Project: Mayberry PUD2 + Filing 1 "Tract K Development"

Subject: Ellicott Fire Protection District Review Comments & Response

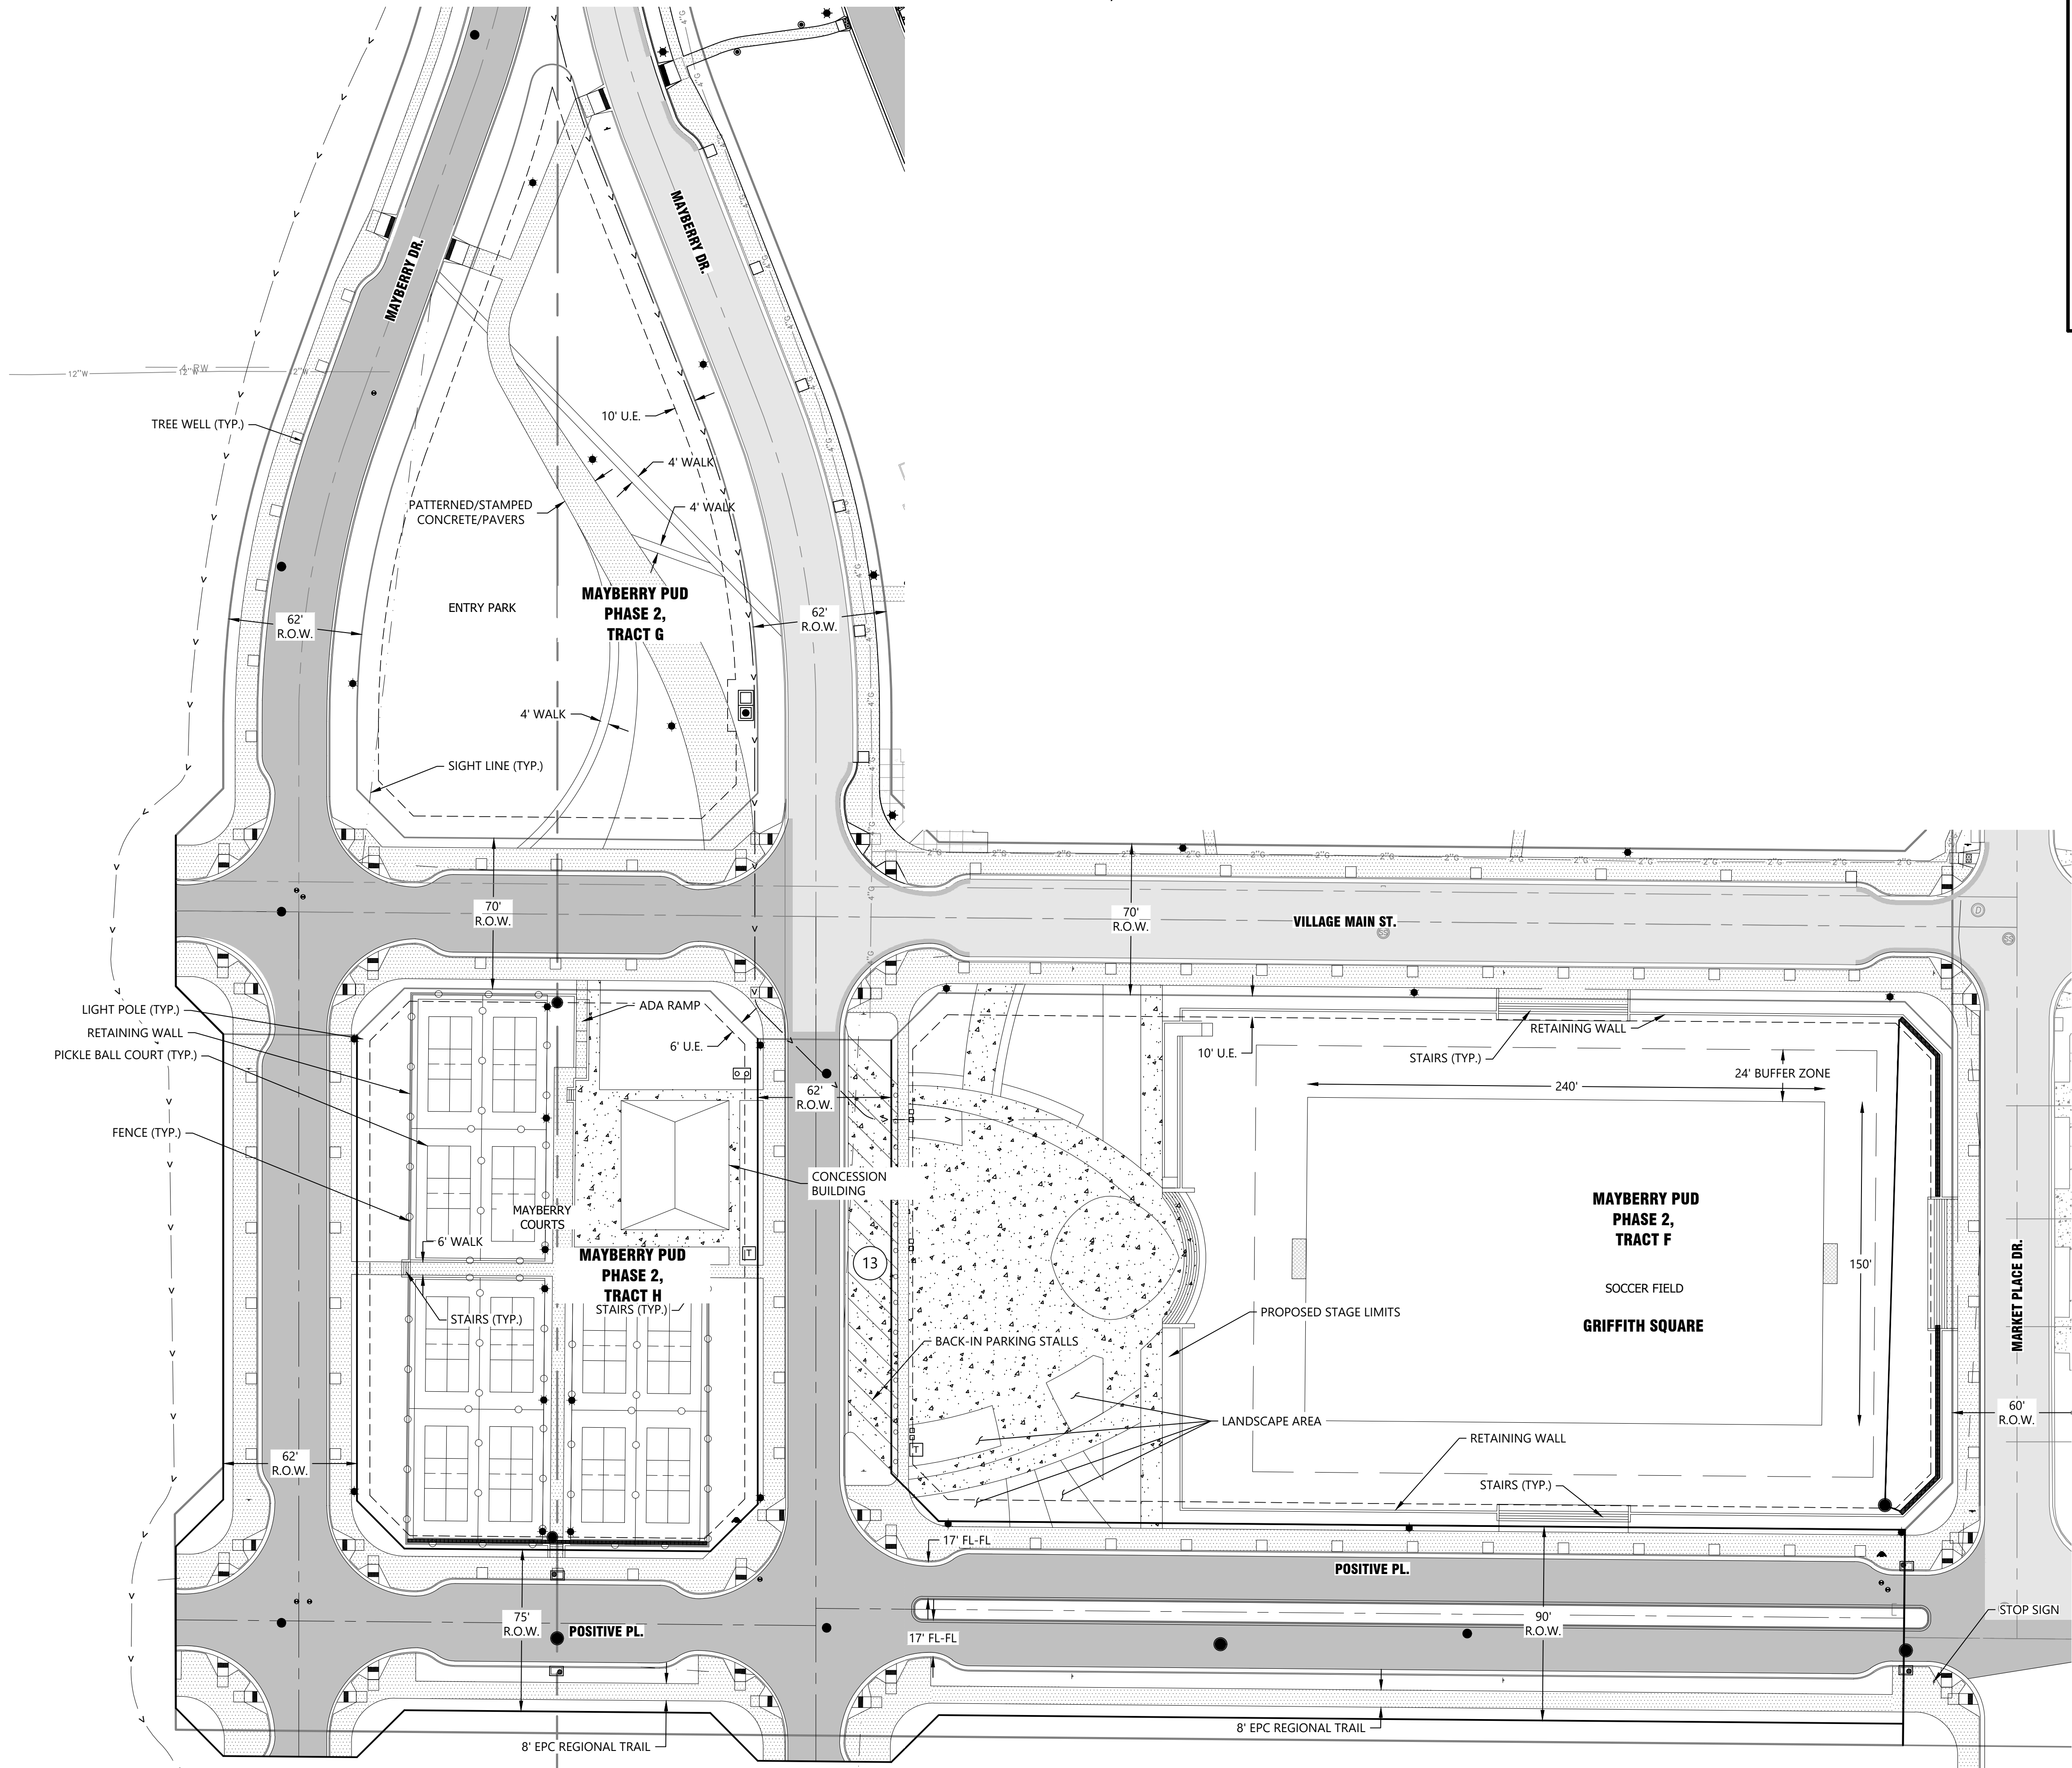
EFPD Comment: "The size and type of structure is not addressed in the fire protection report so it is impossible to say if the purposed design is adequate."

- MC Response: The proposed housing product was illustrated on sheet 13 of the submitted PUDSP plan set. Total square footage was not provided, but dimensioned footprints were included (this information has been added to the plan sheets). The Fire Protection Report states that structures will be constructed in accordance with applicable codes. In absence of identifying the specific building materials, one can assume the homes are to be constructed of combustible light-frame residential construction with fire protection detailing to be established at time of building permit. Unless specifically stated, most single-family and two-family dwelling units are typically in this classification.

The Fire Protection Report has been updated to include a statement that the structures will be of combustible light-frame residential construction complying with the 2021 IRC and PPRBD amendments, with required rated assemblies where prescribed.

No. 15

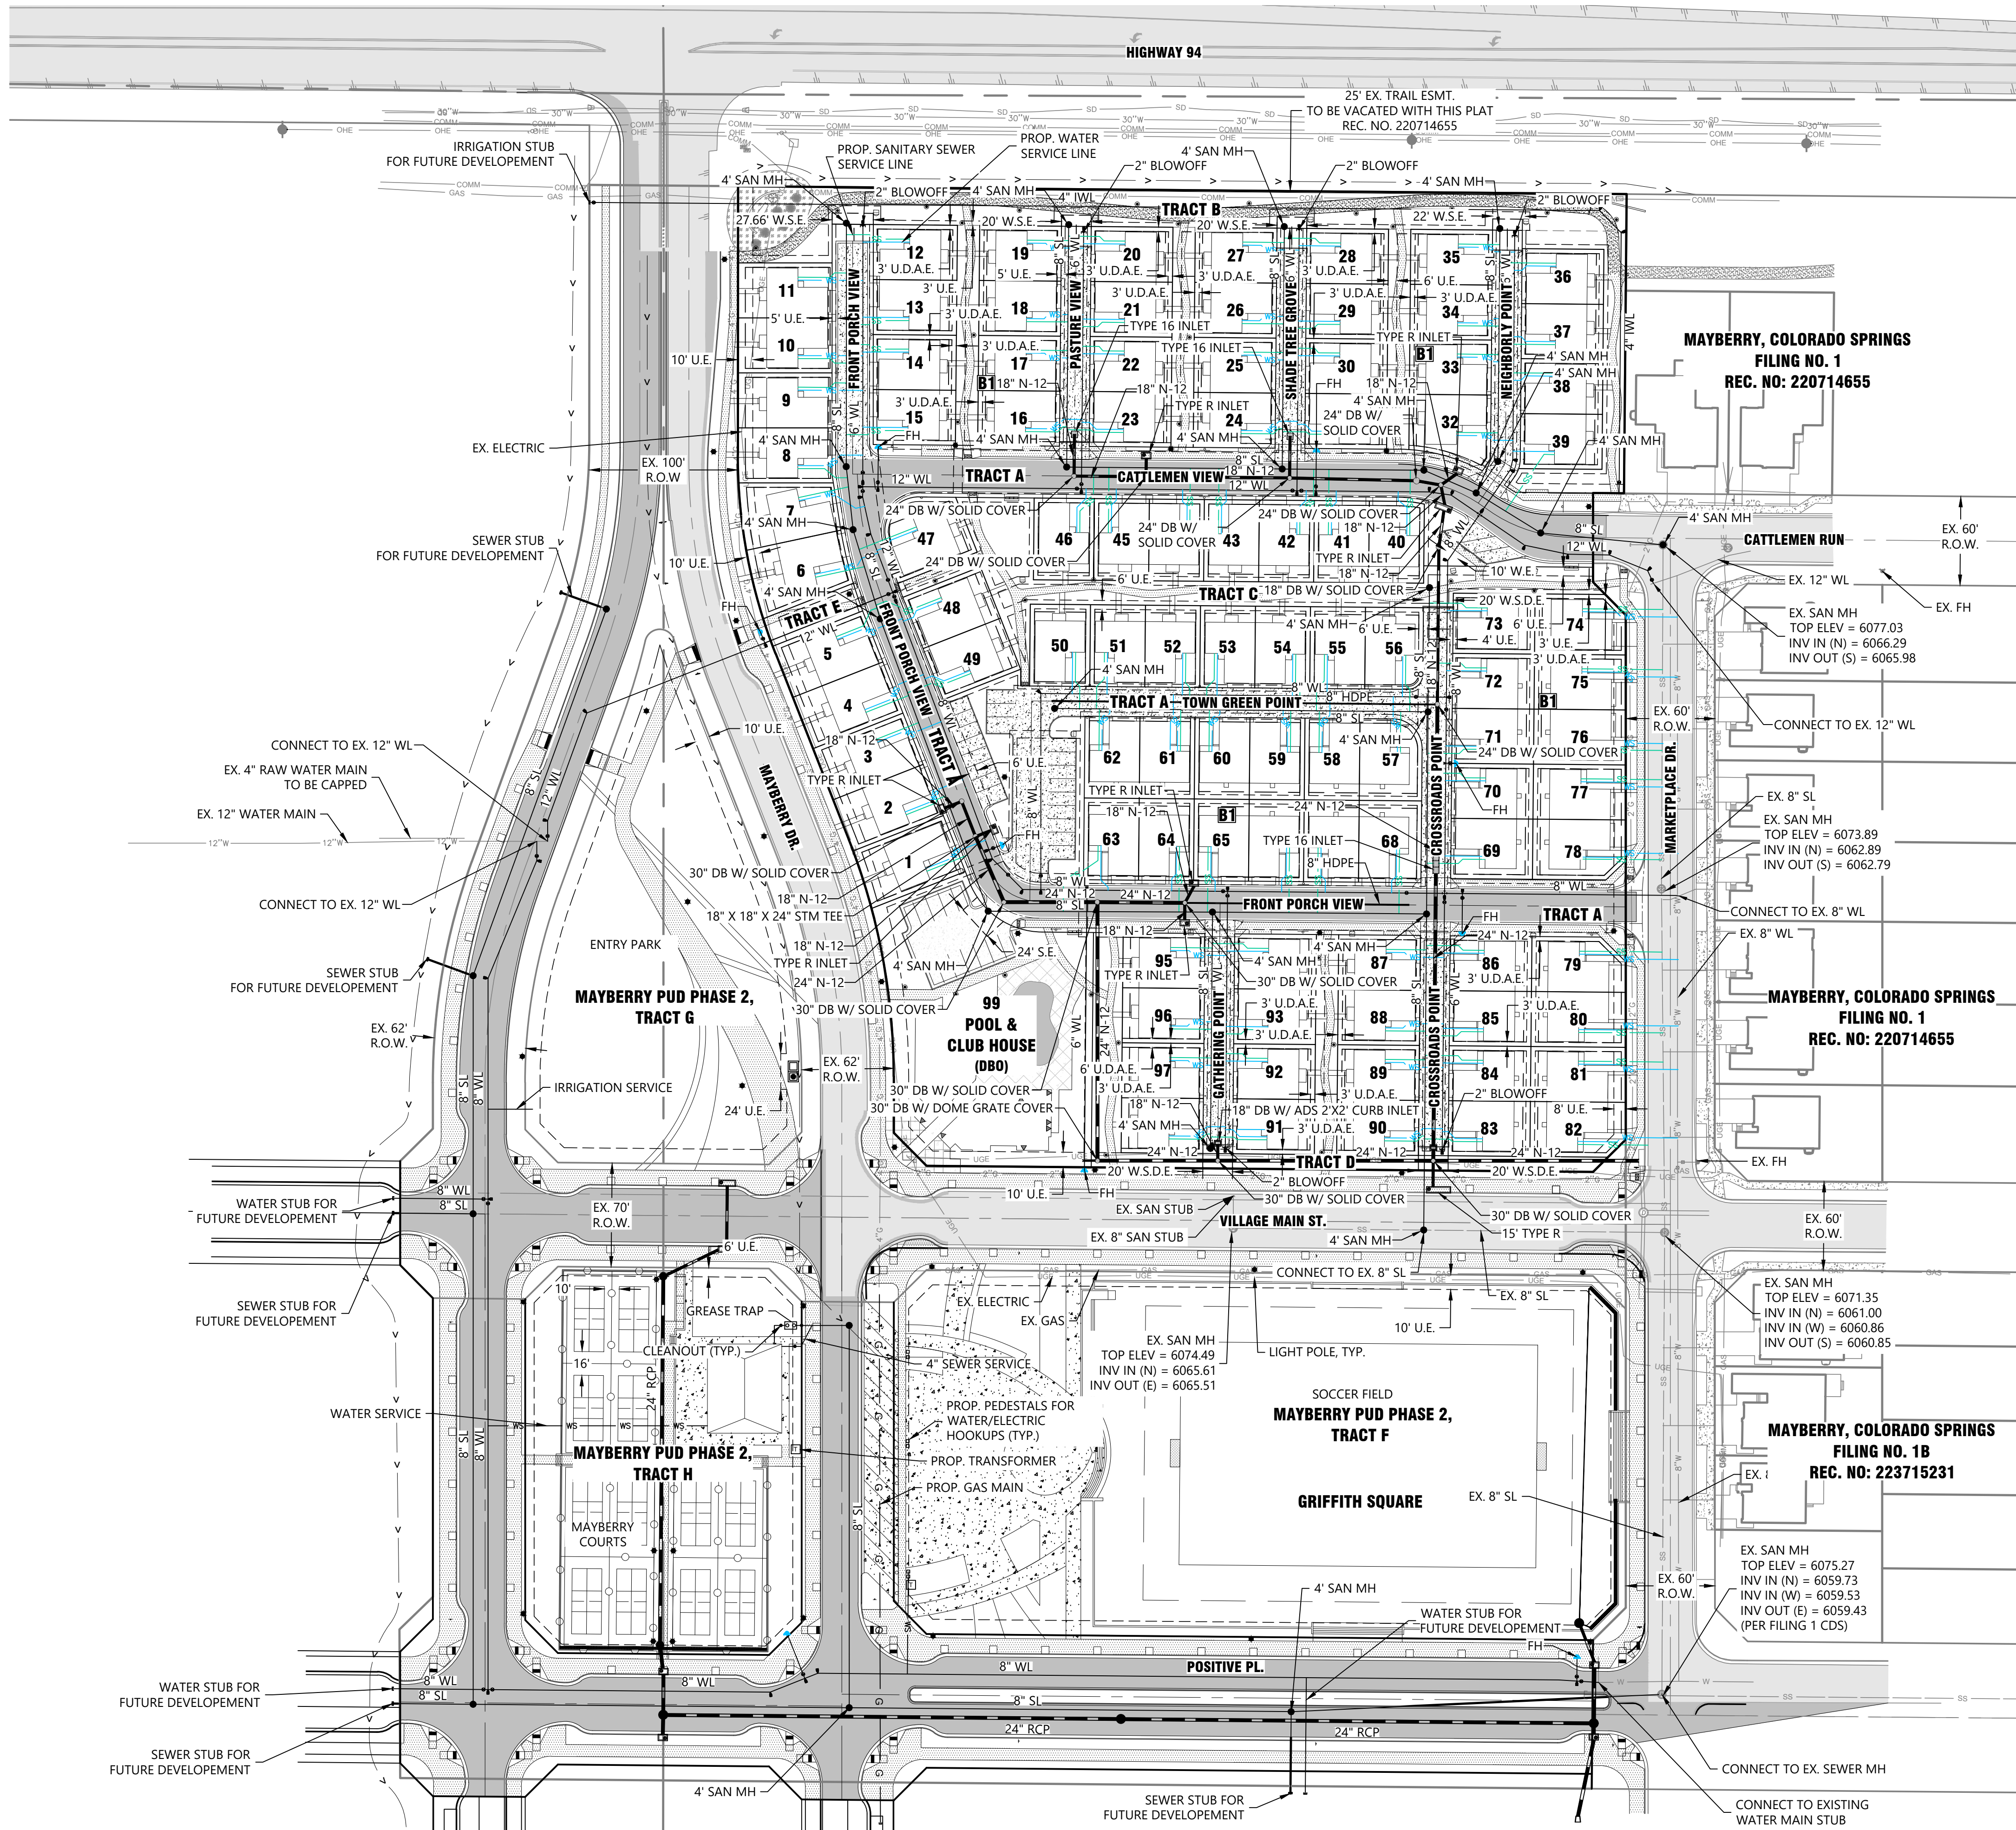
EFPD Comment: "The adopted fire code requires a minimum of 1,500 gallons per minute with hydrants spaced no more than 500 feet apart based on the size and construction type of the structure built."

- MC Response: As stated in the Fire Protection Report, Mayberry acknowledges and agrees to provide the minimum 1500gpm hydrant requirements. Fire hydrants have been proposed throughout the development (as depicted on sheet 15 of the submitted PUDSP plan set). Mayberry would welcome any feedback EFPD may have regarding the proposed placement of these hydrants so that fire protection operations can be effectively executed.
